Phone: 0300 123 6780
Email: Kathryn.Walsh@lancashire.gov.uk
Your ref: 3/2025/0181
Our ref: 3/2025/0181/HDC/KW
Date: 02 April 2025

Location: Blue Slates Sunnyside Avenue Ribchester PR3 3ZE
Proposal: Proposed addition of a timber boundary fence on top of the existing white rendered dwarf wall to an overall height not exceeding 1.8m high to the Sunnyside Avenue and Fort Avenue boundaries of the site.
Grid Ref: 364886 435306

PROPOSED
FENCE ELEVATION (C)

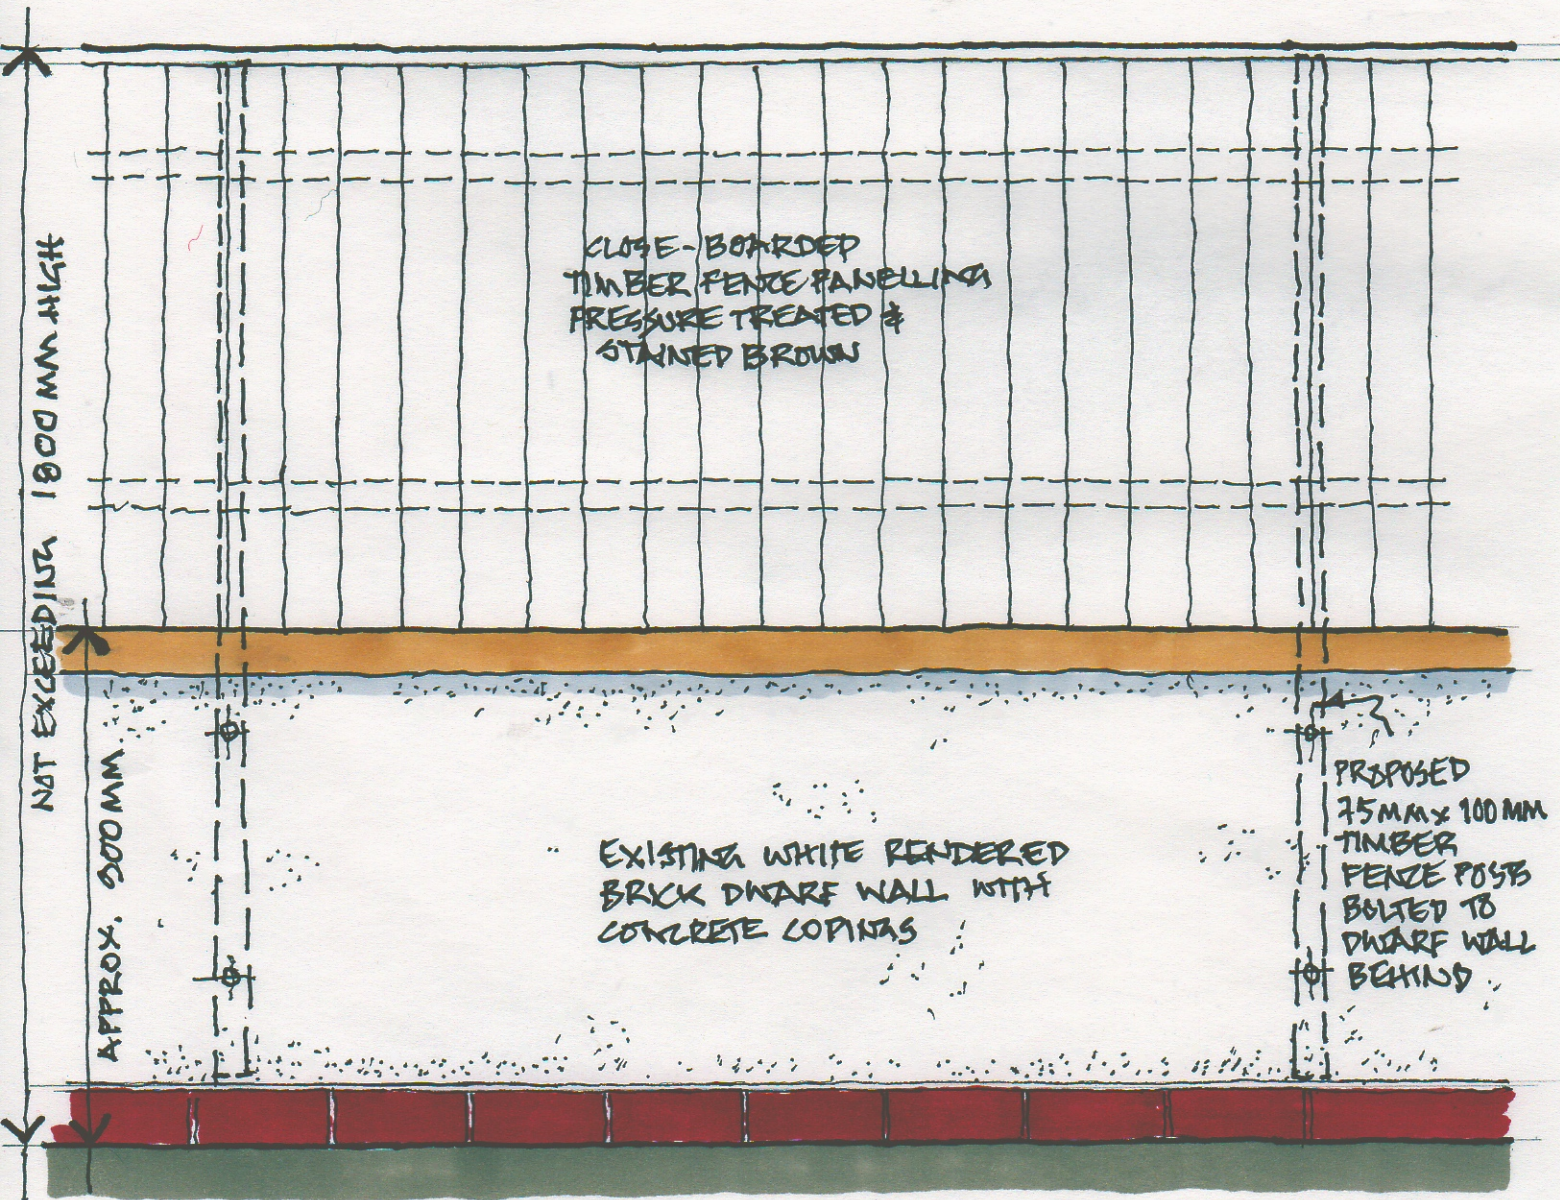
The proposal will result in a 1.8m fence line within close proximity to the site access and the proposed fenceline follows the existing low wall around the boundary of the property on to Sunnyside Avenue as such the LHA has concerns regarding visibility at the existing access to the dwelling as well as at the junction of Sunnyside Avenue and Fort Avenue.

Therefore the applicant should provide visibility splay drawings at both the existing access to the dwelling and at the junction of Sunnyside Avenue and Fort Avenue this will assist the LHA in understanding if the development is likely to impede visibility in both locations.

To ensure adequate intervisibility between highway users at the existing dwelling access a visibility splay set 2 metres back from the near edge of the carriageway and extending 25 metres along the nearside carriageway edge to the northwest of the access shall be provided. (The site line requirement is based on table 7.1 from Manual for Streets).

To ensure adequate intervisibility between highway users at the junction of Sunnyside Avenue and Fort Avenue a visibility splay set 2.4 metres back from the near edge of the carriageway and extending 25 metres along the nearside carriageway edge to the north of the access shall be provided.

The visibility splay should be wholly within the land which the applicant controls and/or the adopted highway and nothing shall be erected, retained, planted and / or allowed to grow at or above a height of 0.9 metres above the nearside carriageway level which would obstruct the visibility splay of the proposed access.

The applicant should provide accurate details of the required sight line requirement, before determining the application.
